M3 J9 ISH2 2nd AUG_PT2

Okay. Thank you, ladies and gentlemen. Think we're all back. So I will resume this hearing at 1135 and continue with our discussion about air quality. Um, item two on the air quality agenda is construction phase impacts. Um, so a question to Winchester City Council. In your local impact report, you state that there's a commitment to the Section 61 Control of Pollution Act 1974 and prior consent is welcomed and early dialogue is requested with so that the Council can be satisfied that mitigation during construction delivers and will provide the level of mitigation assumed within Chapter 11.

PROJECT STAGE  
**PCF STAGE 3**

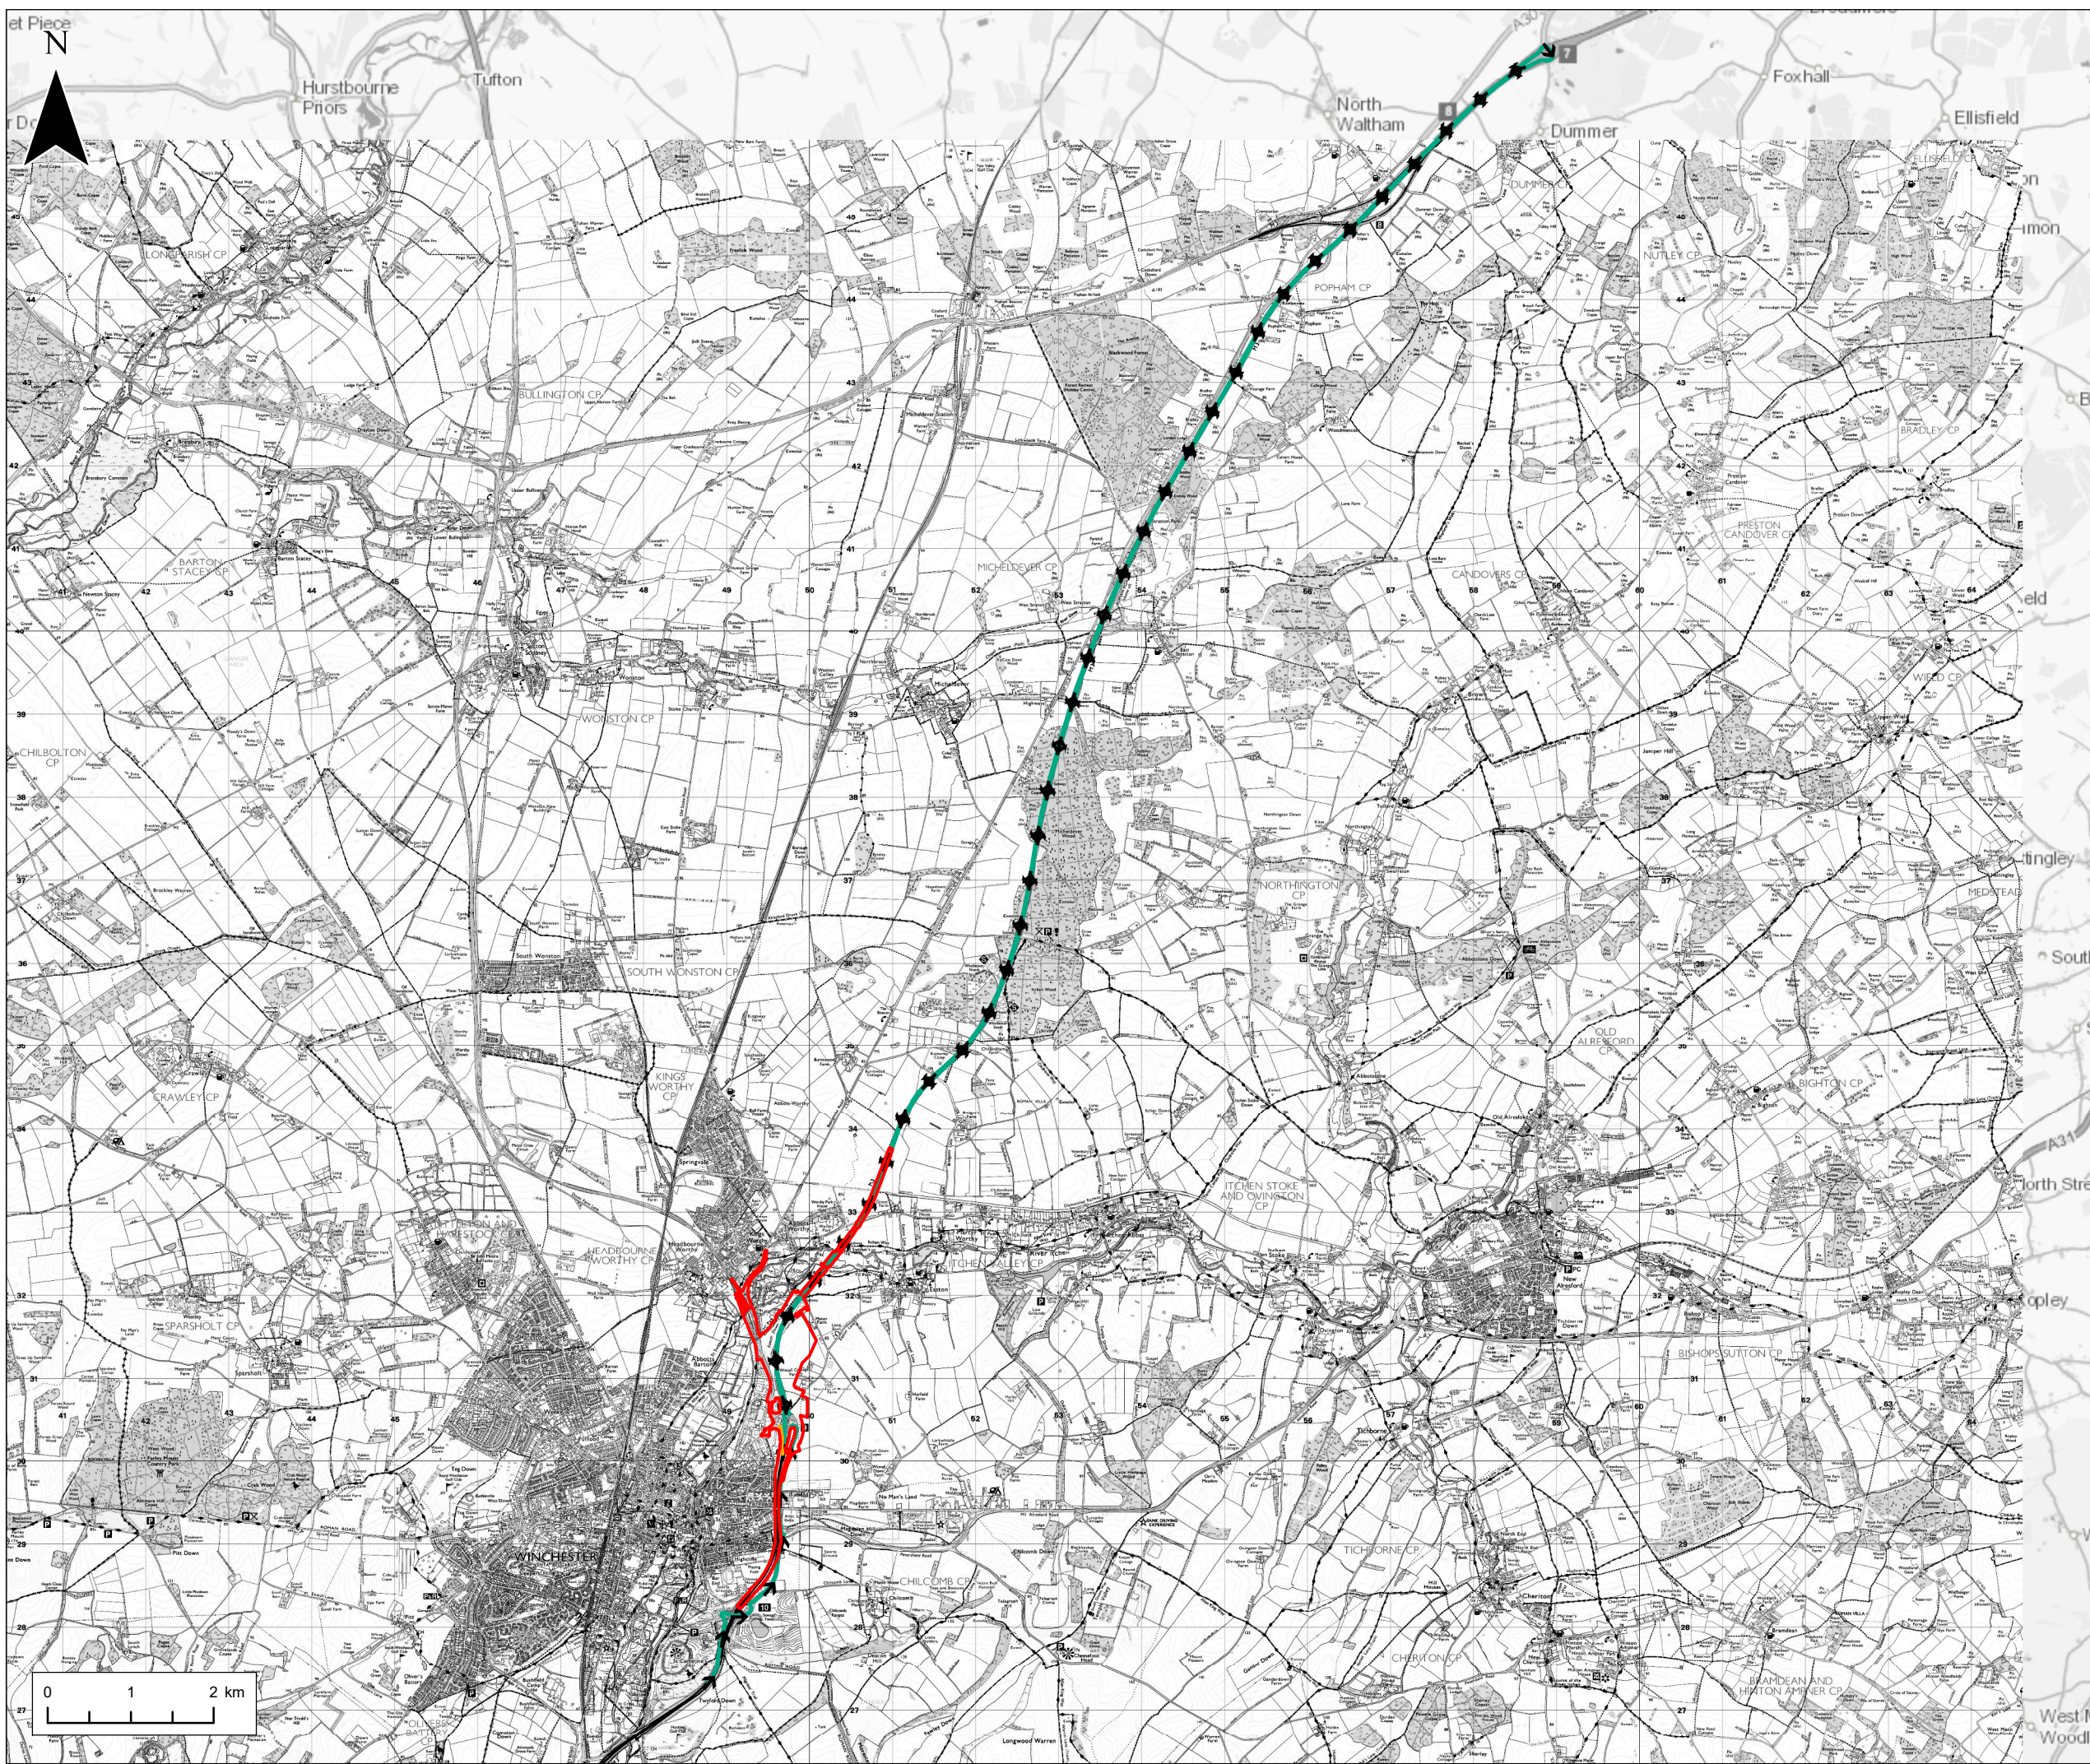
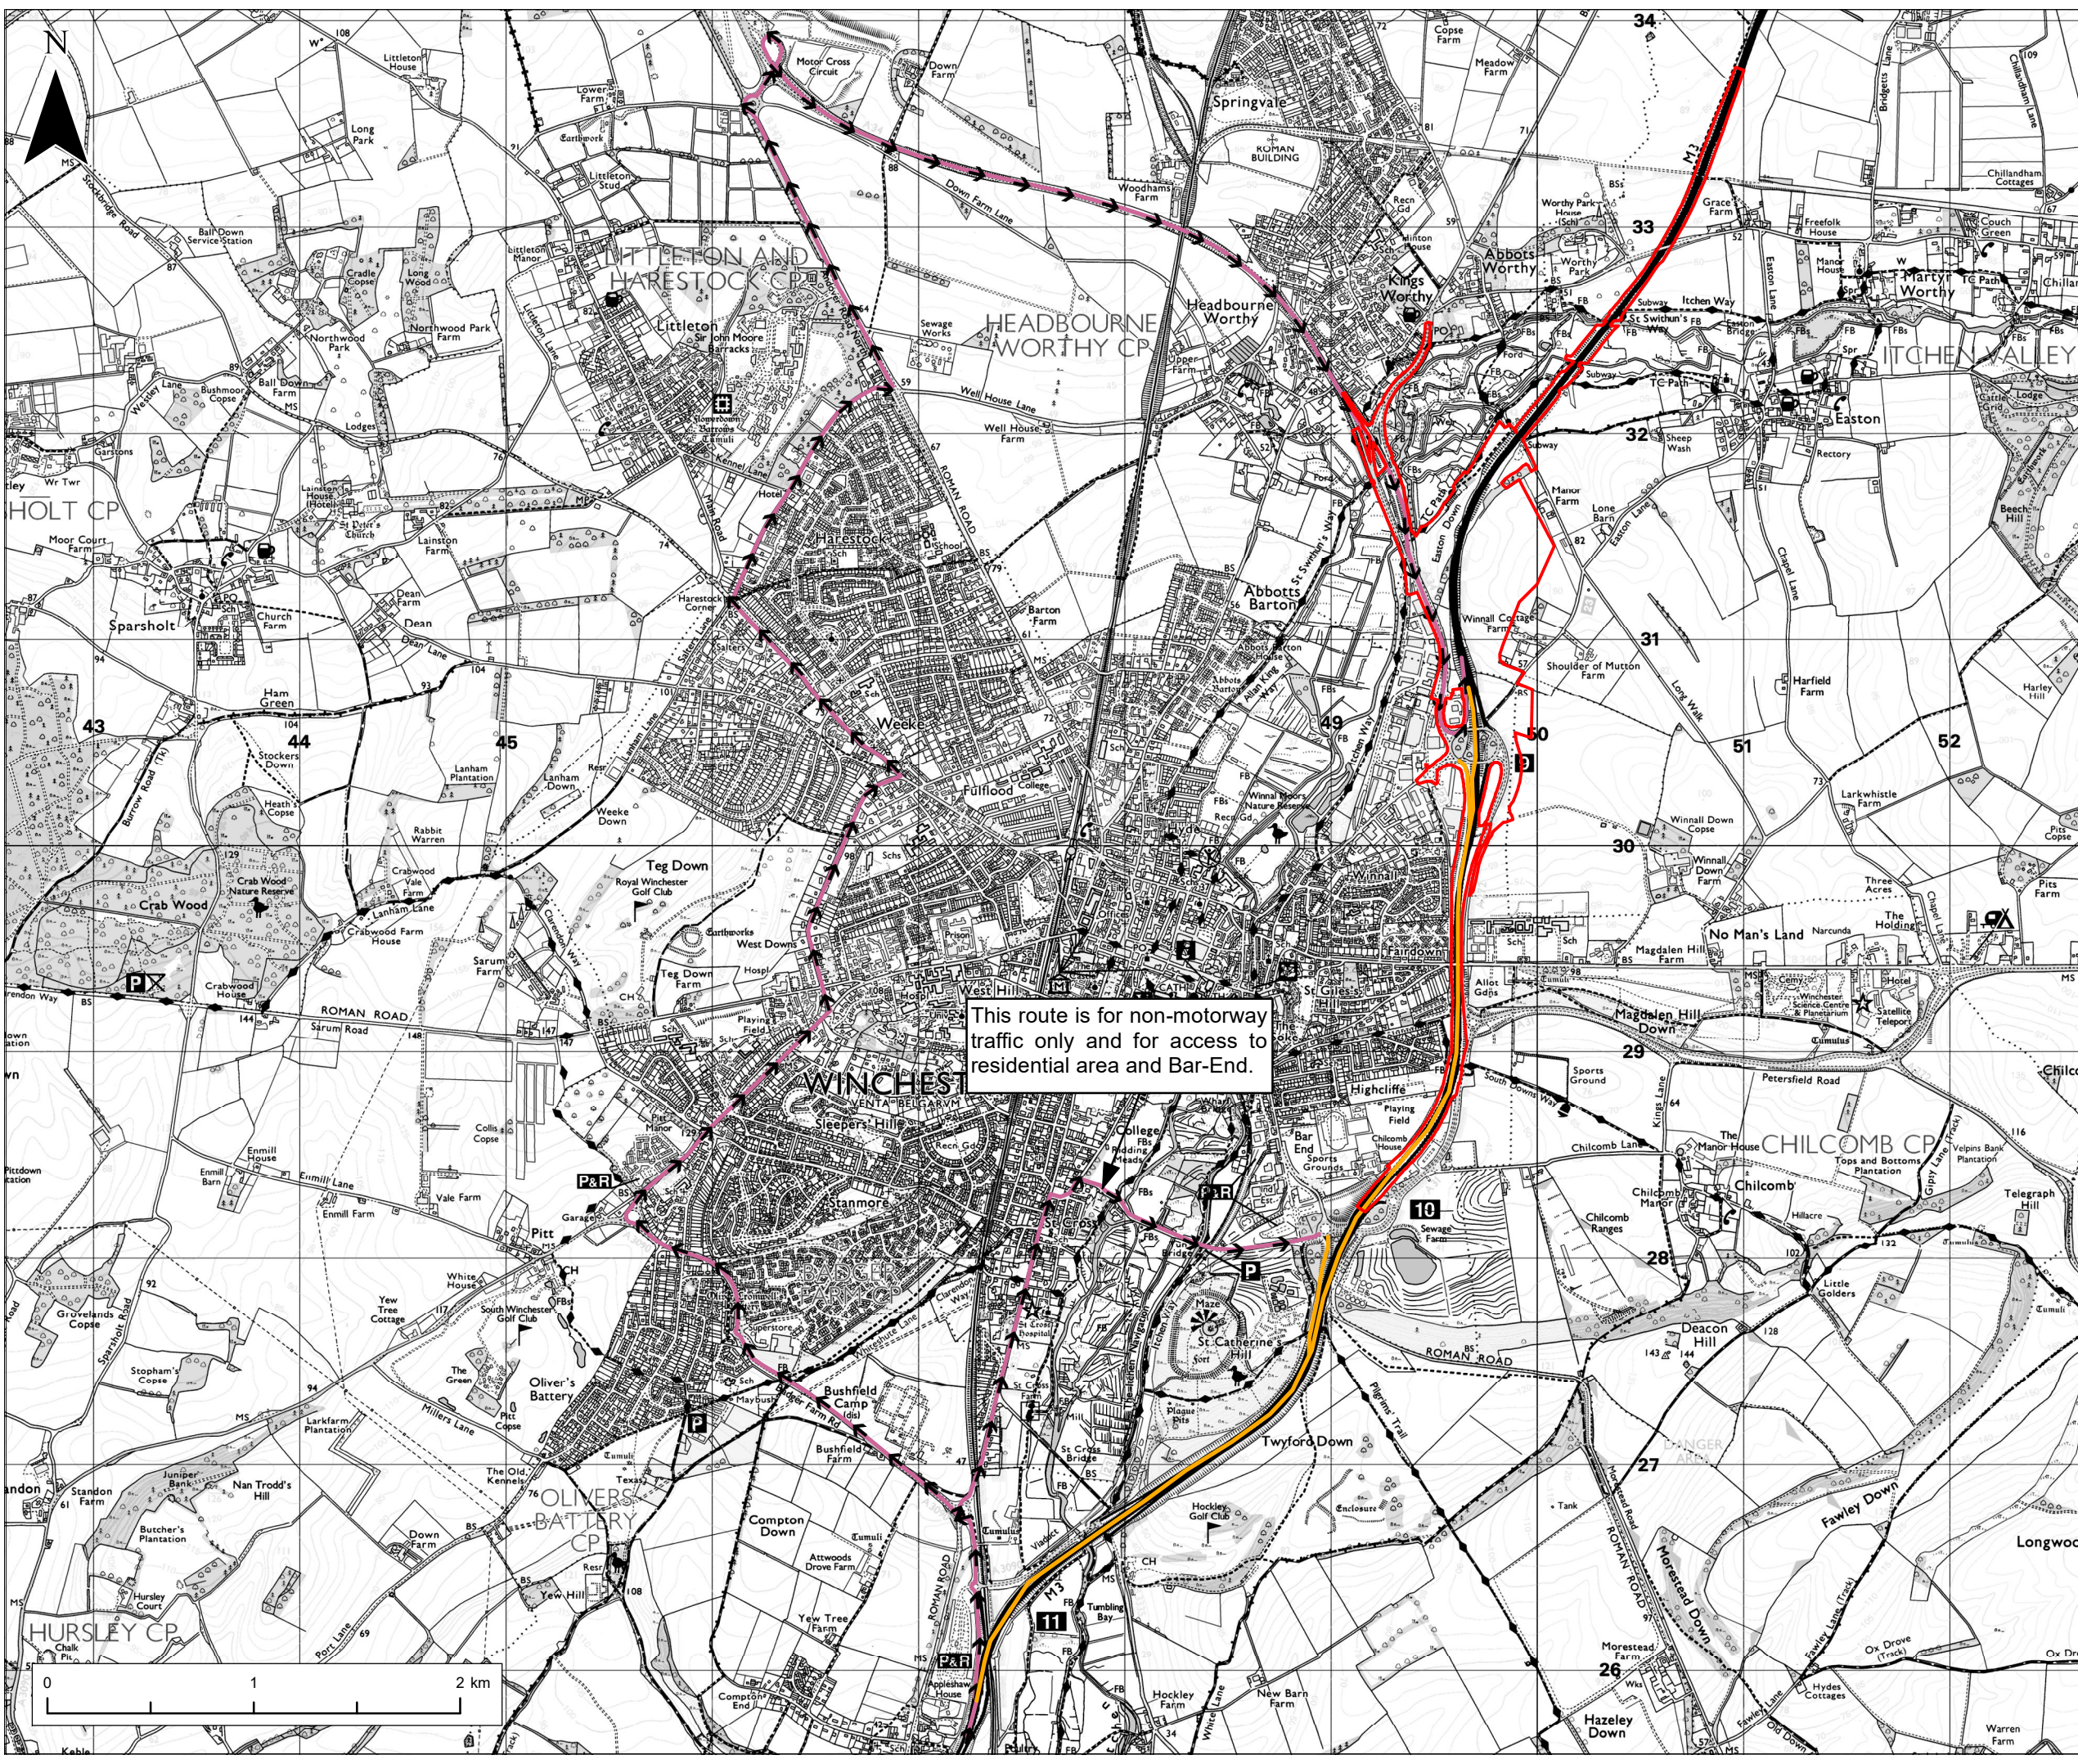
So so on the understand, we're talking about equality in more general terms. Um, we've already raised our concerns about potential adverse effects within the, um, during the construction phase for both resulting from traffic diversions and potentially in the days of Google and similar other things, the voluntary rerouting that people perform due to congestion. And that's of concern during the construction phase. Um, we've noted the applicant's comments, um, on our, our 102 page 72 of the applicant's response to relevant representations.

But we don't feel that satisfactorily answers our concerns. So still no reference to air quality impacts within a detailed diversion assessment methodology methodology. And we'd request that such criteria is listed and considered and reviewed as part of that consideration.

We had filters at Winchester City. We do have some concerns in relation to the methodology with the the assumption of or diversions will be followed in the modeling methodology performed, which in reality I think we would all agree it's not the case and particular reference, we'd just like some more work done on that. And in reference to the consideration of the including in a diversion assessment, some reference to air quality which still doesn't exist.

So we'd like that to be more formally acknowledged. The overall methodology, yes, but we do have we have no issue with it in a high level, but we do have issue with that that detail in terms of the way they've assessed the divergence and the impacts and particular reference to a potential daytime diversions and and congestion and acknowledge that will be try to be limited. And the assessment demonstrates nighttime closures.

But I think we need to see more work on the bits where that won't be the case and more discussion and assessment of that, sir.

both through the sort of the main construction period when the northbound on slip is closed and the potential for diverted flows then. But we've looked at that and really because that northbound on slip is not heavily trafficked, that kind of redistribution of flows doesn't lead to a risk of air quality impacts. You then have the sort of the closure diversions and closure routes discussion that we've we've touched upon. But again, there's the sort of the overnight closures etcetera, aren't considered likely to lead to air quality impacts because we're looking at sort of the annual air quality conditions and these occasional overnight closures and diversions aren't considered a risk from that that regard.

Yeah. Katherine Tracy for the applicant. Happy to continue to have the dialogue as part of the statement of Common ground and and flesh it out outside of this process, the hearing. Um, but in terms of the diversionary routes, um, they will, as we explained yesterday, subject to some sort of emergency closures, will be overnight or extended weekend closures, limited number of them during the construction period. The only long term closure is the M3 junction nine on the slip.

Um, and that has been modeled to and the modeling suggests that actually the number of vehicles that we use that won't generate significant impacts on, on the traffic network that would lead to any significant air quality impacts across the network. Um, however, we can work to flesh out that response if it's not currently to the satisfaction of Winchester City Council in terms of diversion routes and the joys of taking people on whichever route that the satnav considers is appropriate.

That is not that's an endemic problem that every traffic scheme and including, you know, Winchester local closures and things will have. So we can have a discussion about that. But I'm not entirely sure that that's within the bounds of the developer to to fix. We will be monitoring diversion routes that we put in place. Um, drivers and alike tend to stick to them now. Think they've learned the errors of their ways with satnav. Um, but that it is possible during monitoring for additional traffic management measures to be put in place.
